Condition no.3

APPLICATION NO: BR/289/17/DOC

Site Address: 36 Corbishley Road Bognor Regis PO22 9HR

Description of Works: Application for approval of matters reserved by condition imposed under BR/110/17/PL relating to conditions 3-surface water drainage, 6-site set up during construction, 7-schedule or materials & finishes, 8-landscape scheme, 9-details/plans of new screen walls & fences, 11-details of car parking spaces, 12-details of cycle parking & 13-details of dustbin enclosures.

Client
Mrs Patricia Paul
Drawing Title
Surface Water Drainage

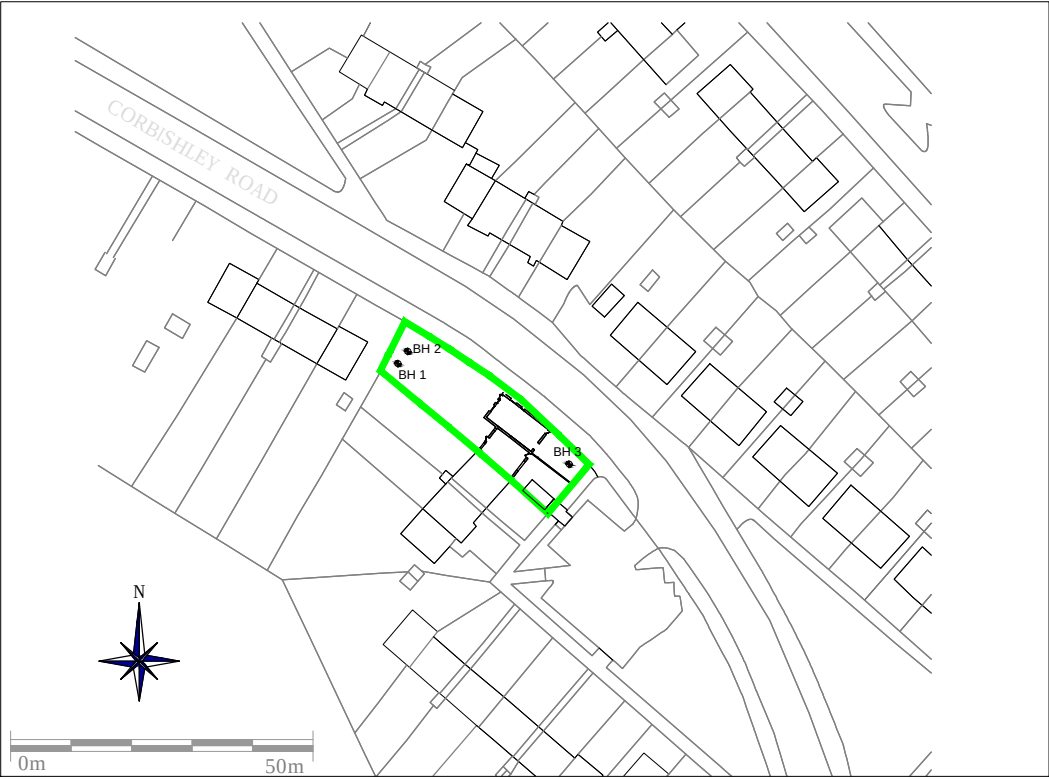
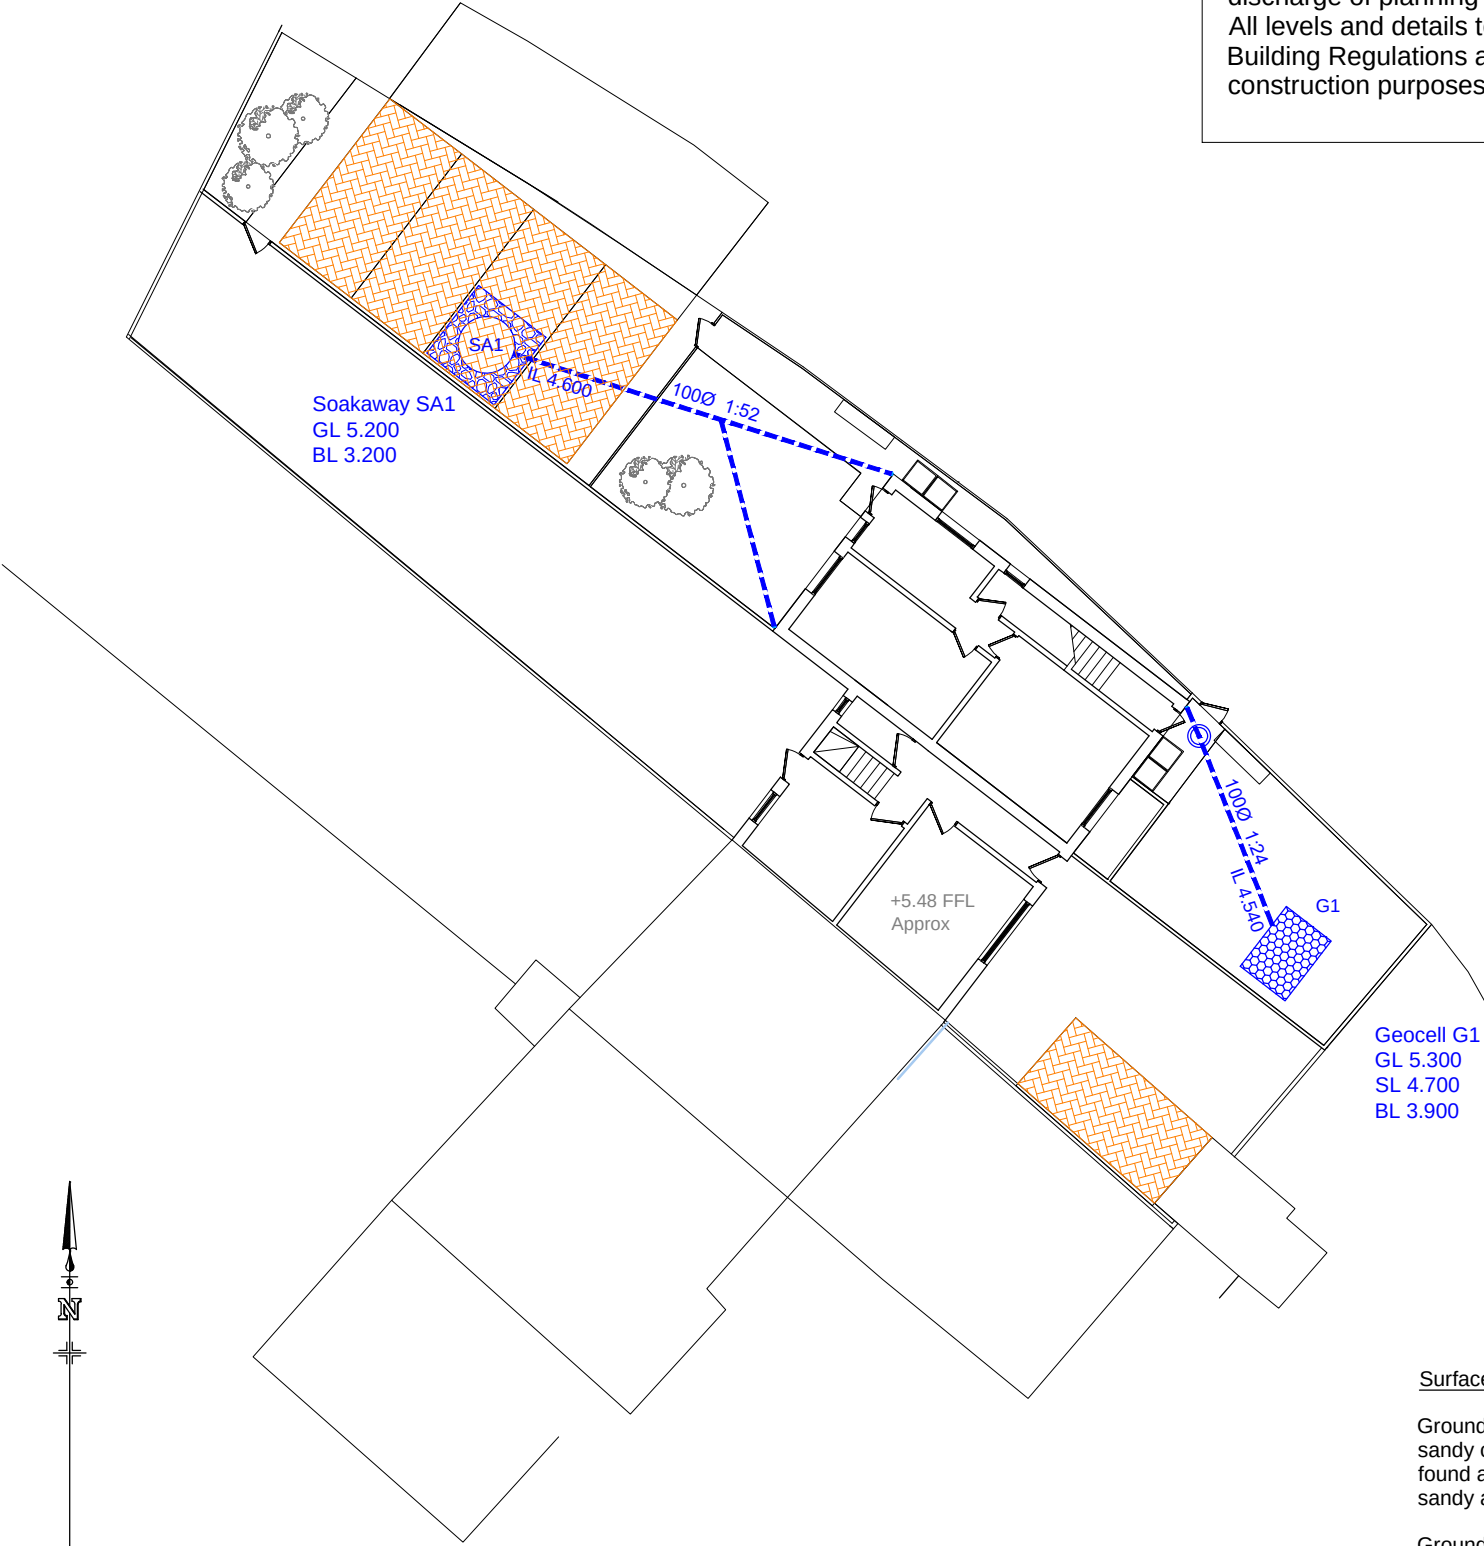
1. No winter groundwater data or winter percolation testing results have been provided. This information needs to be gathered at an agreed time during the winter and will inform the drainage design.
2. A detailed drainage design (layout/construction details) will be required.
3. Hydraulic calculations are required to prove that the 1 in 100 year storm event + climate change allowance can be accommodated within the drainage scheme/on site.
